Appeal Decision

Appeal Ref: APP/A2525/W/23/3329045

14 Cross Street, Fleet, Spalding PE12 7BD

- The appeal is made under section 78 of the Town and Country Planning Act 1990 (as amended) against a refusal to grant planning permission.
- The appeal is made by Mr Adrian Wright against the decision of South Holland District Council.
- The application Ref is H05-0294-23.
- The development proposed is dwelling and detached garage.

Client:	Mr Adrian Wright
Drawn:	AMW
Checked:	AMW
Date:	22.03.23
Scale:	As shown
Page No.:	1
Page Size:	A1
Job No.:	082202
Draw No.:	PD101
Stage:	Planning
Revision:	P2

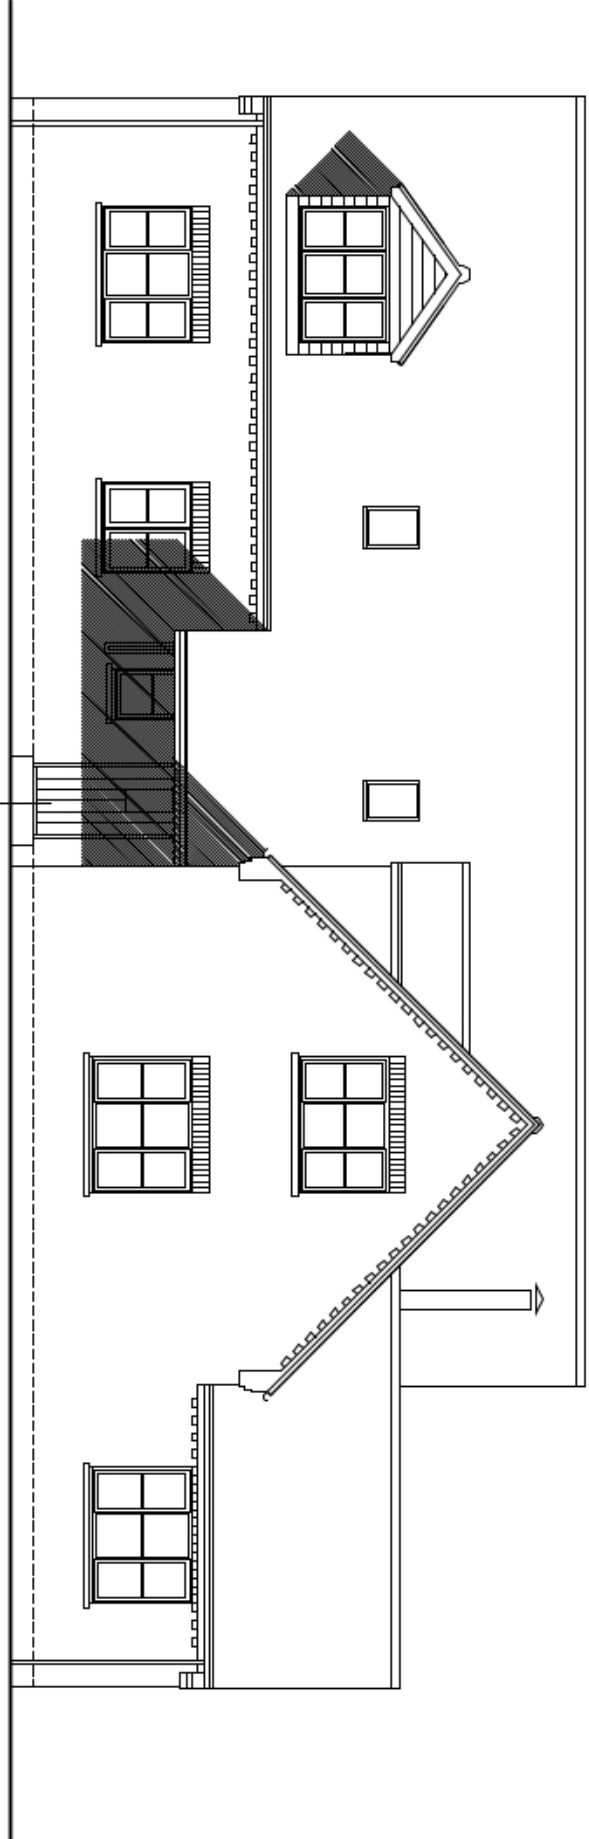
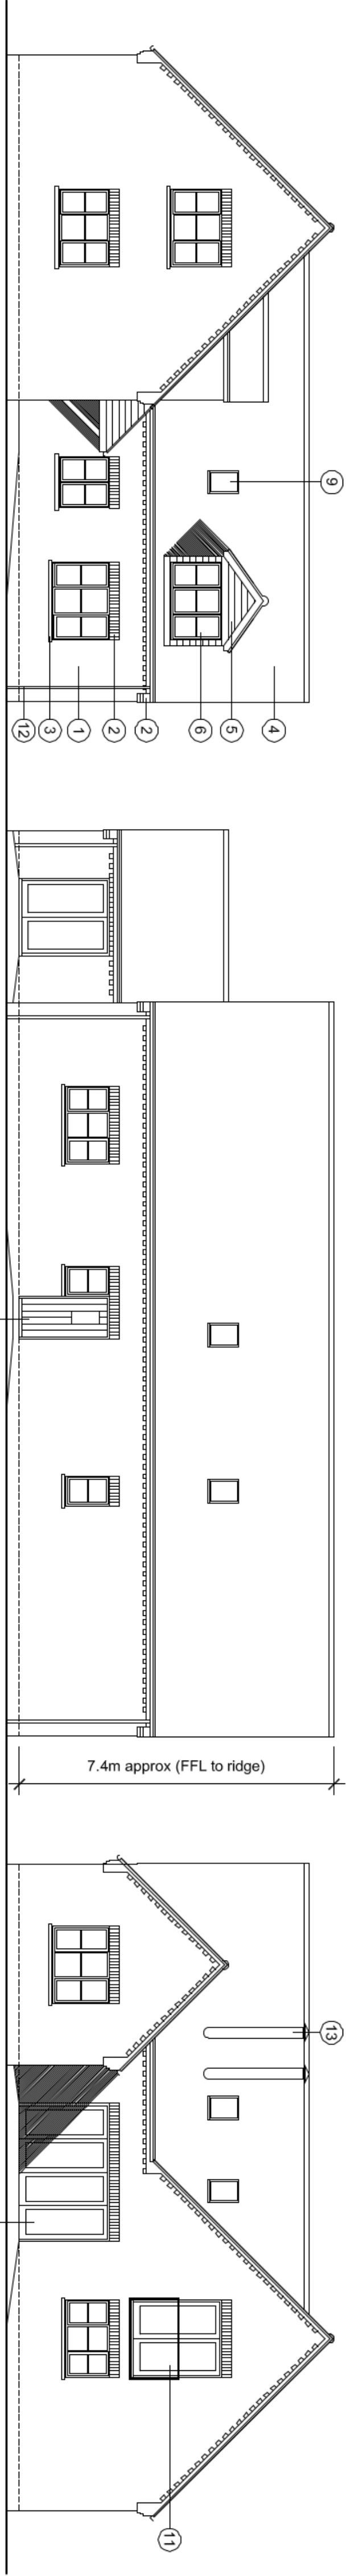
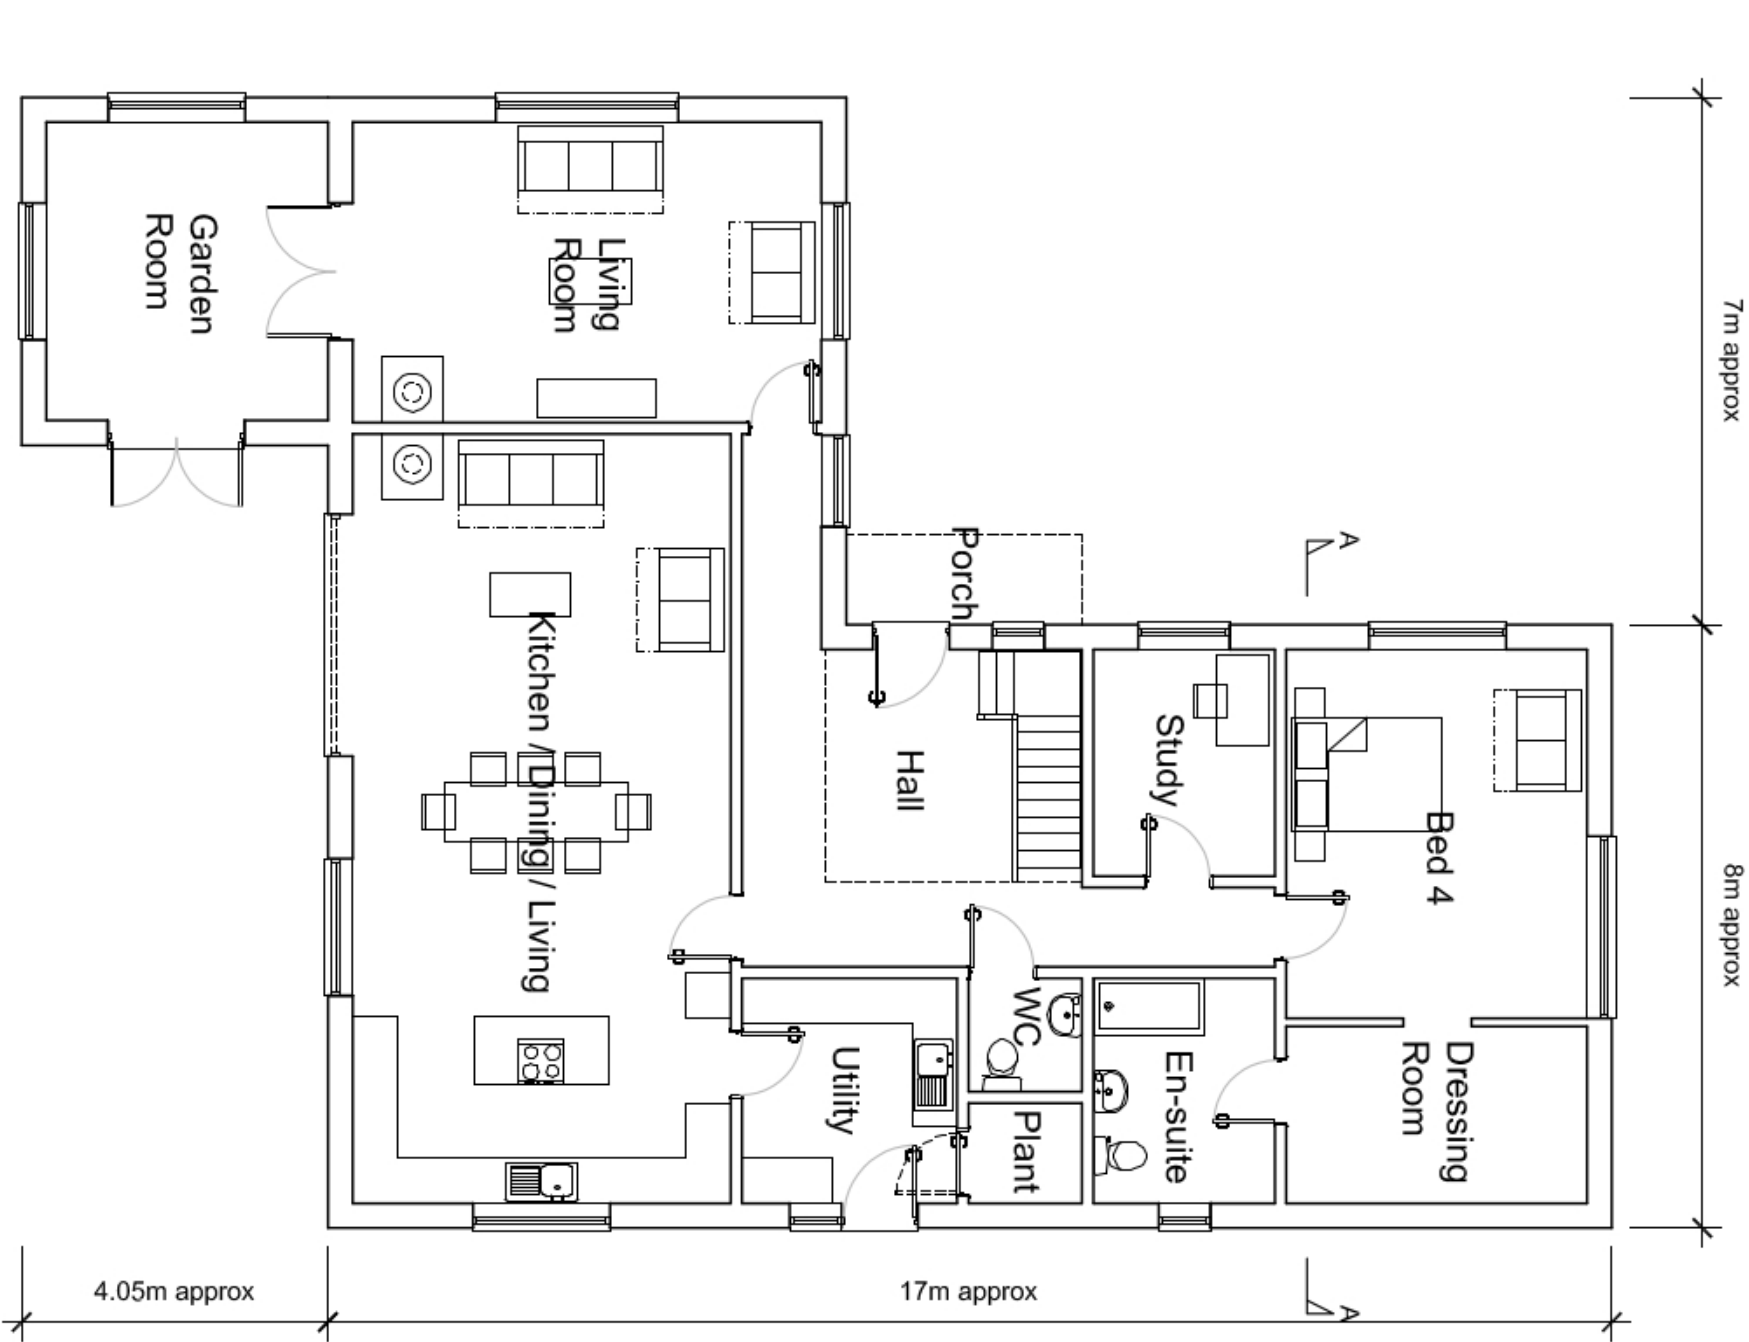
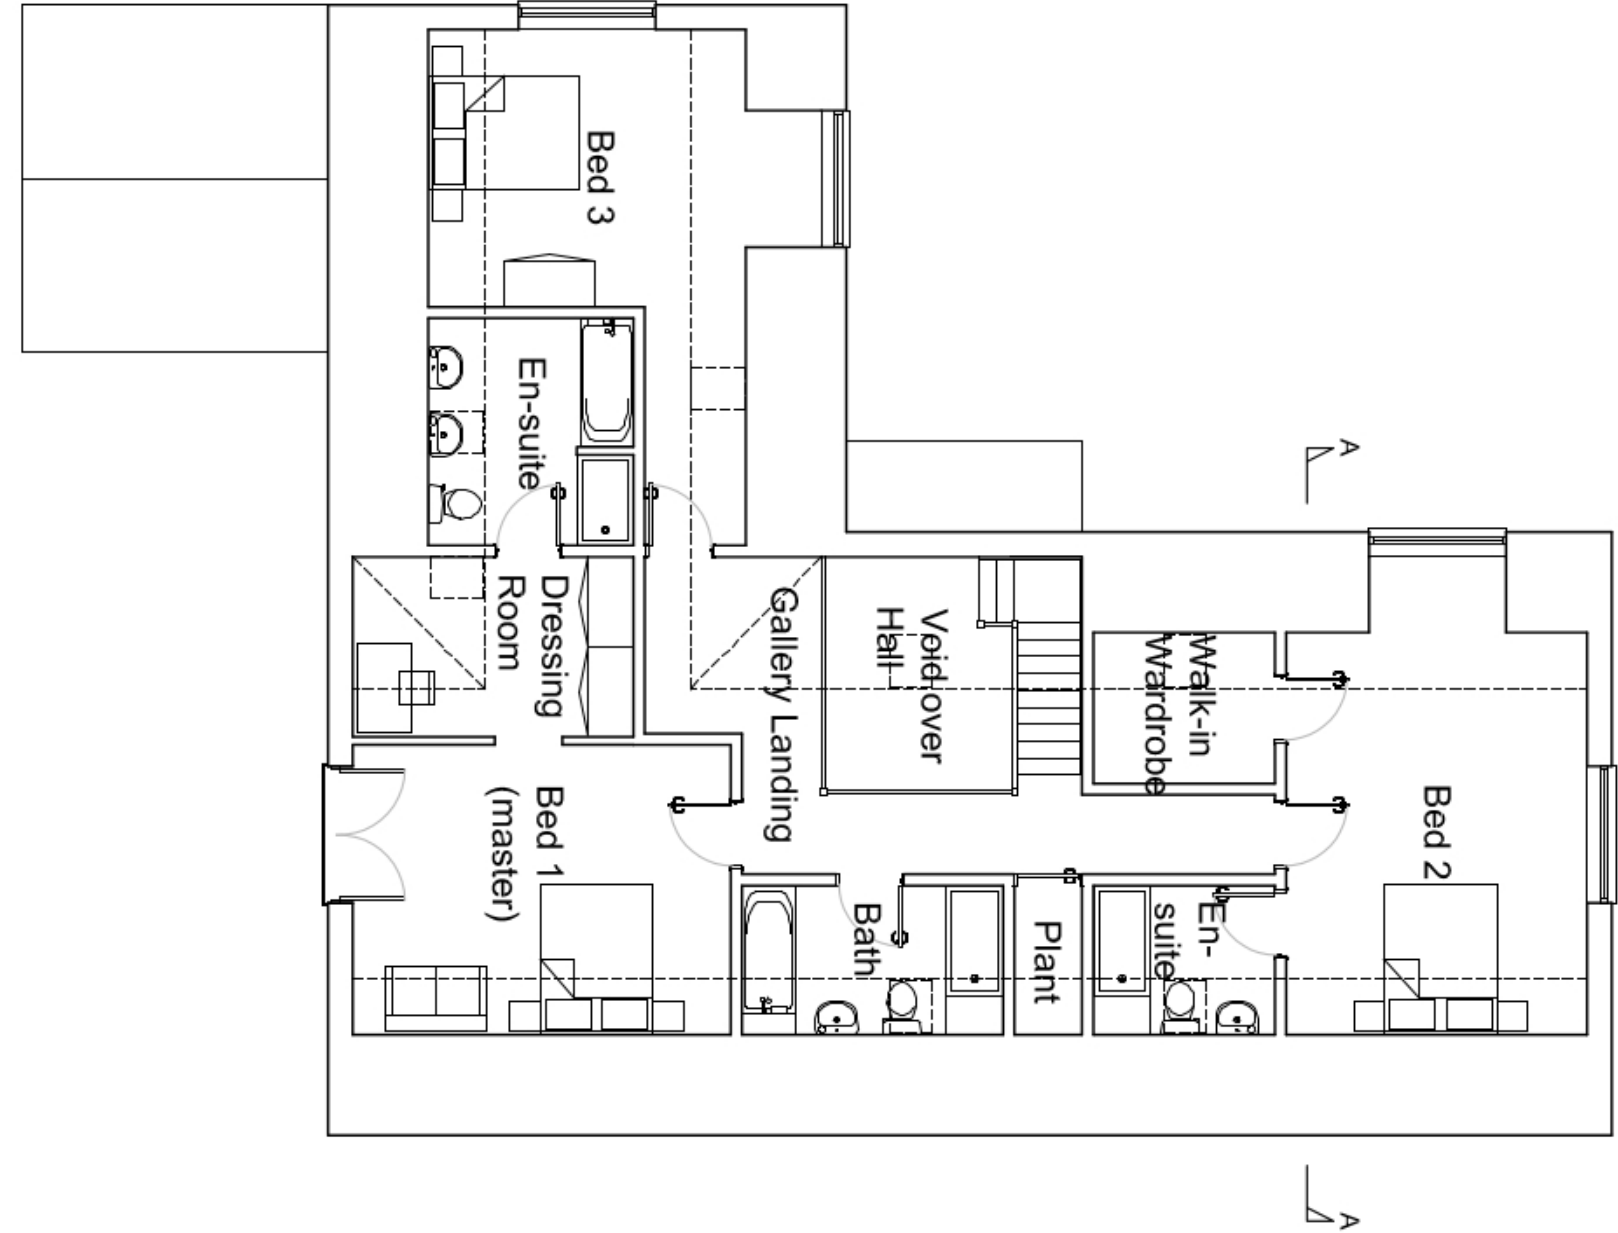
5. The position of the proposed dwelling to the side and rear of the existing dwelling at No 14 would not on its own be dissimilar to the respective positions of No 14 and 'Green Lodge'. However, the height of the dwelling and the greater presence of first-floor elements would appear incongruous alongside the more modestly scaled bungalows to this side of the street. The considerable size of the garage combined with its position within an L-shaped plot would significantly curtail the rear garden serving No 14. Together these factors would result in a cramped arrangement of buildings that would detract from the general consistency of scale and the spacious character to this side of Cross Street.

9. The proposal would incorporate a roof which would be angled away from No 18. However, the ridge height at approximately 7.4 metres and depth of the dwelling would combine to form a side profile of considerable mass. Due to its position very close to the shared boundary with No 18 and its substantial projection beyond the rear elevation of this neighbouring dwelling, it would have a dominating presence. This would be particularly the case when experienced from the nearest rear elevation kitchen window at No 18 and parts of the patio area that sit closest to the boundary such that it would unacceptably reduce the quality of outlook for occupiers of No 18.

Proposed Block Plan (1:250)

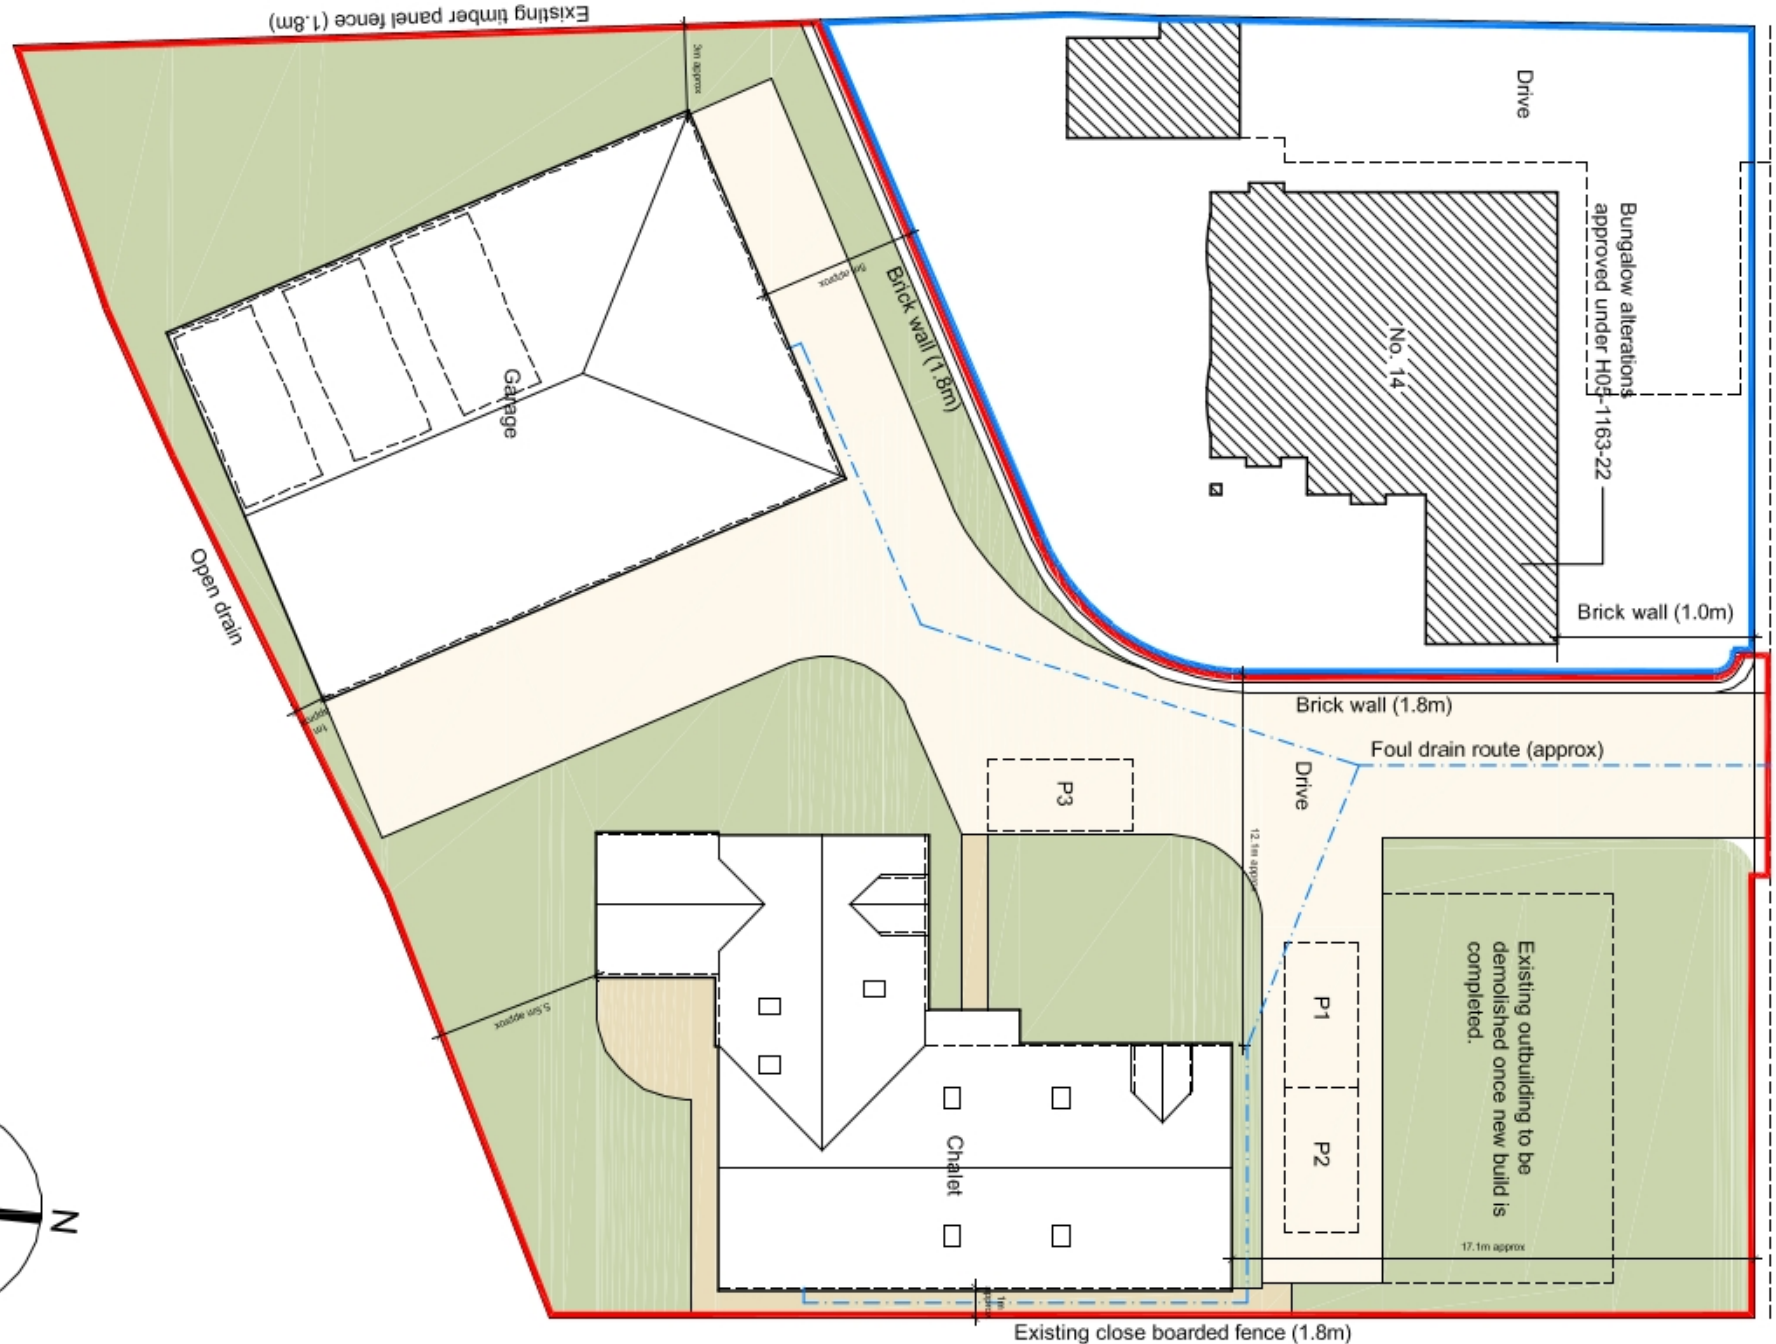
13. The proposed driveway and garage would bring new neighbouring activity close to the dwelling and reconfigured rear garden at No 14 Cross Street. Some of the proposed parking spaces would also extend close to the boundary with No 18.

14. However, there is no objective evidence before me to suggest that vehicle movements or other activity associated with a single dwelling would be beyond levels that would usually be expected within a residential area. Furthermore, a brick boundary wall is proposed to the shared boundary with No 14 which would likely provide a sufficient buffer to this property given these factors. Consequently, I consider it unlikely that there would be levels of noise and disturbance that would have a material effect on the living conditions of occupiers of neighbouring properties including Nos 14 and 18.
